Recommendation Report

Application No. FG/156/12

LOCATION: 28 Ferring Street
Ferring

PROPOSAL: Alterations

DRW NO 6b SCALE 1/50 (A3)
PROPOSED FRONT ELEVATION

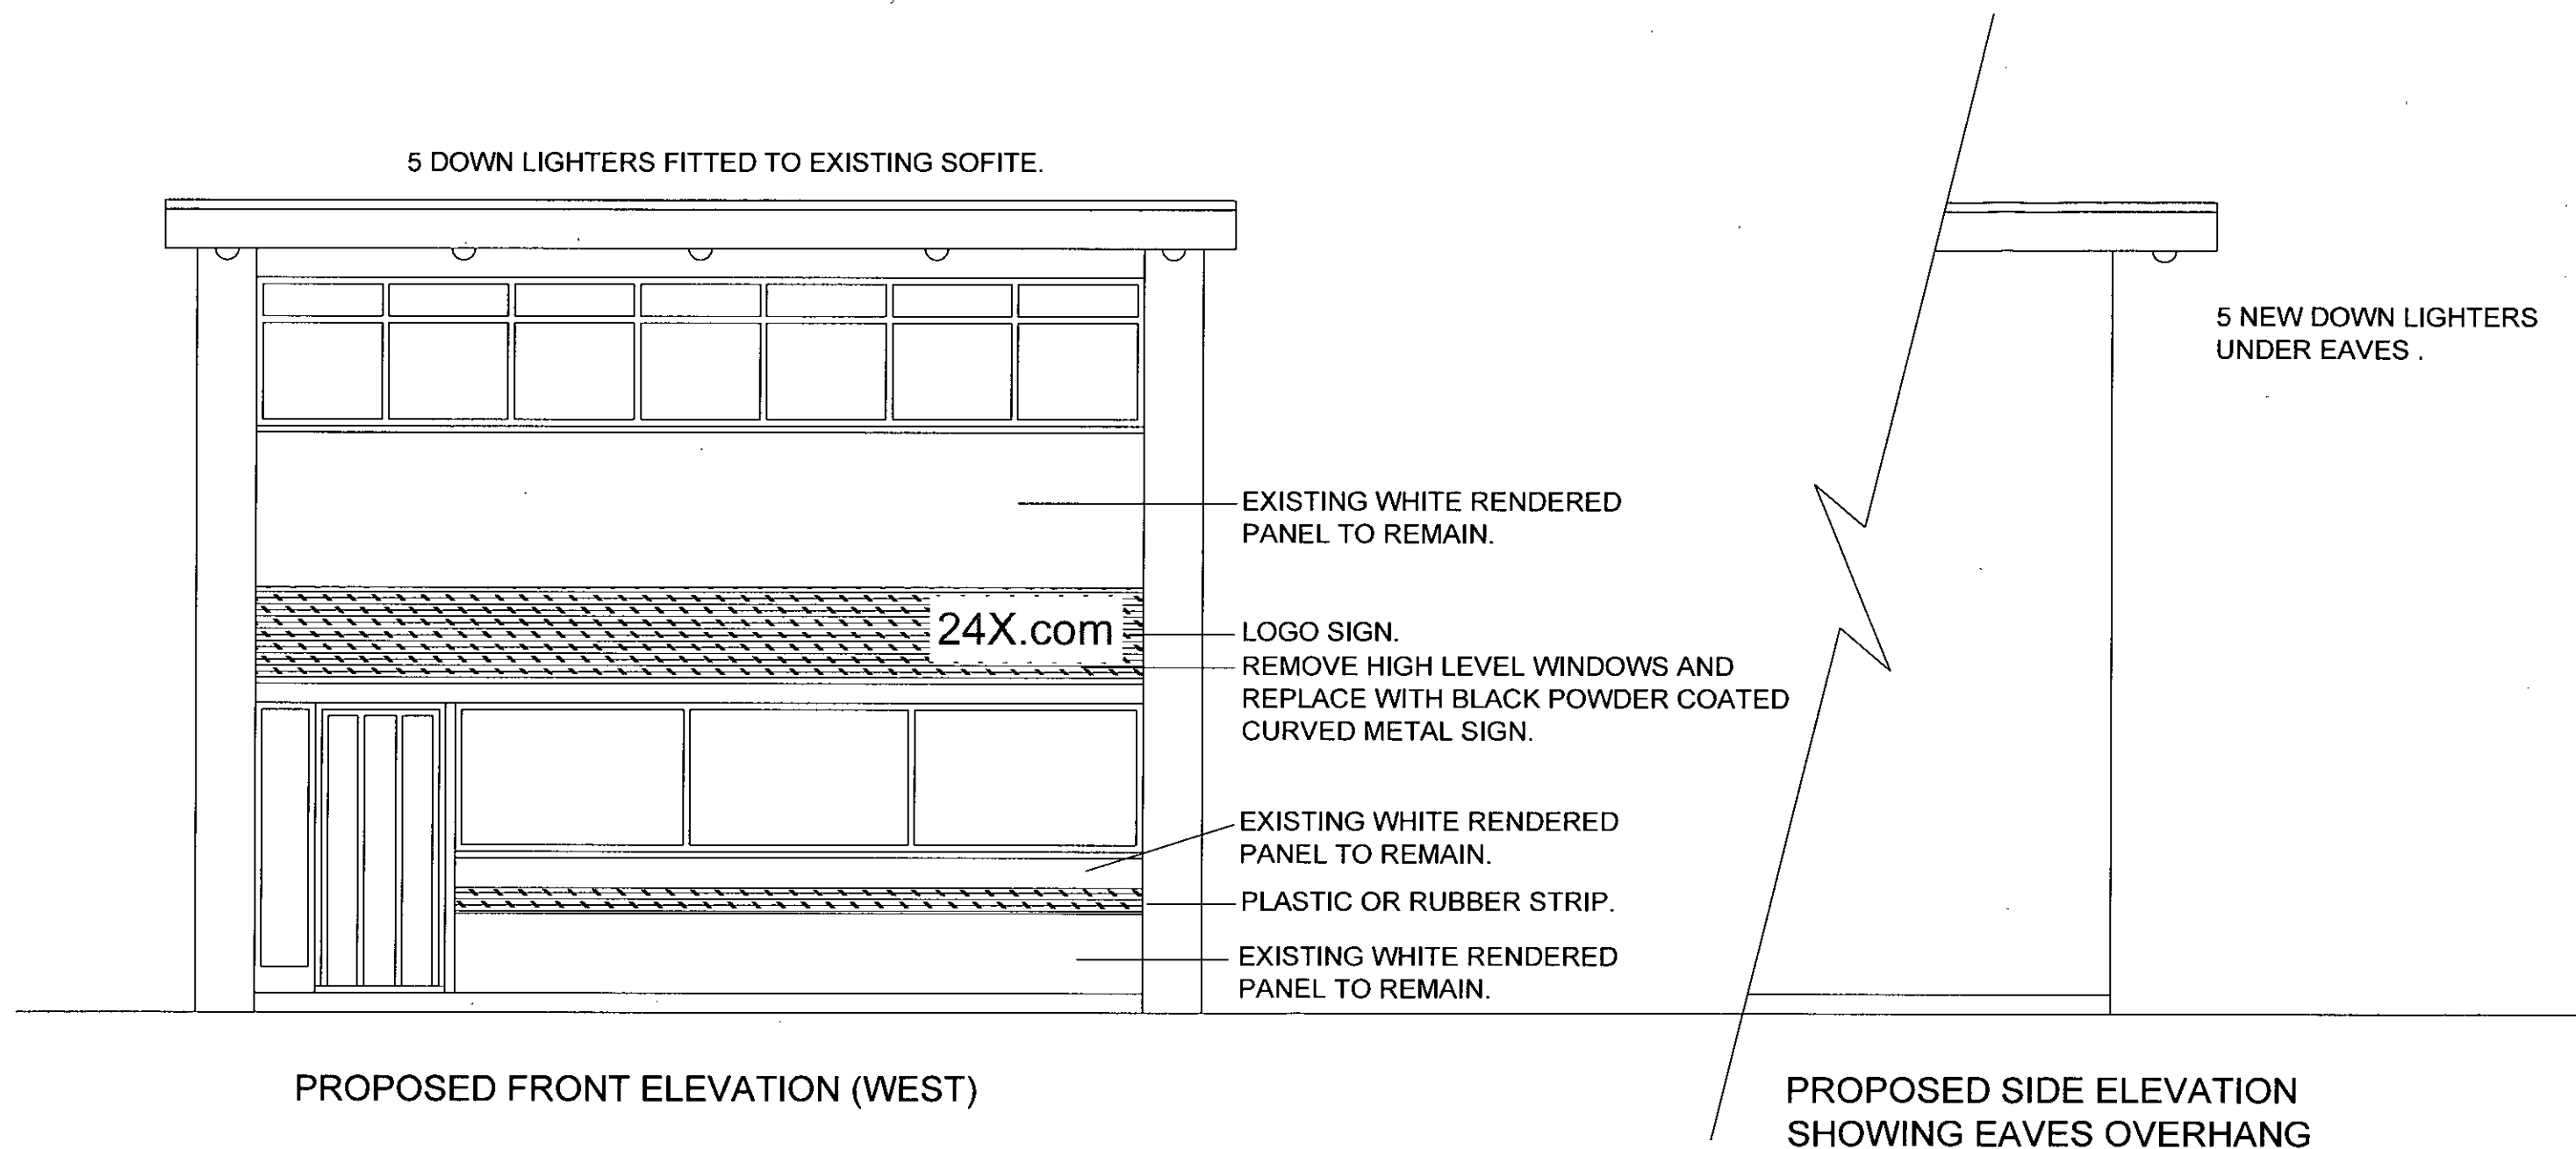
- Objection. The proposed material for the fascia, brushed stainless steel, is totally out of keeping with the surrounding conservation area and we ask that the application be refused.

- Objection. Proposed fascia and lighting do not acknowledge that the premises are immediately adjacent to the Ferring Conservation Area. Not possible to judge what the west elevation will look like or where the lighting will be placed. Nor is there any indication as to what times the lighting is intended to operate. 'Brushed alloy' may possibly be appropriate but it may be rather garish and 'in your face'. We would want to see the fascia and its illumination to be discreet and in keeping with the character of the Conservation Area and, indeed with the character of an undertakers premises.

The five downlights on the front elevation above the first floor level windows will not adversely impact on the amenity of the surrounding area, located 31m from the dwelling opposite the site, GEN33 is satisfied.

With the exception of 'The Barn Surgery' the shops are not in keeping with the adjacent conservation area. The shops are specifically excluded from the Ferring Conservation Area in the Conservation Area Supplementary Planning Guidance. The existing white render will be retained with two black strips proposed to the front elevation.

- It is no longer proposed to use the premises for the purposes of an undertakers. The site will retain the existing use of B1(a) (Business office).
- Brushed alloy cladding has been deleted from the application. Existing white render will be retained.
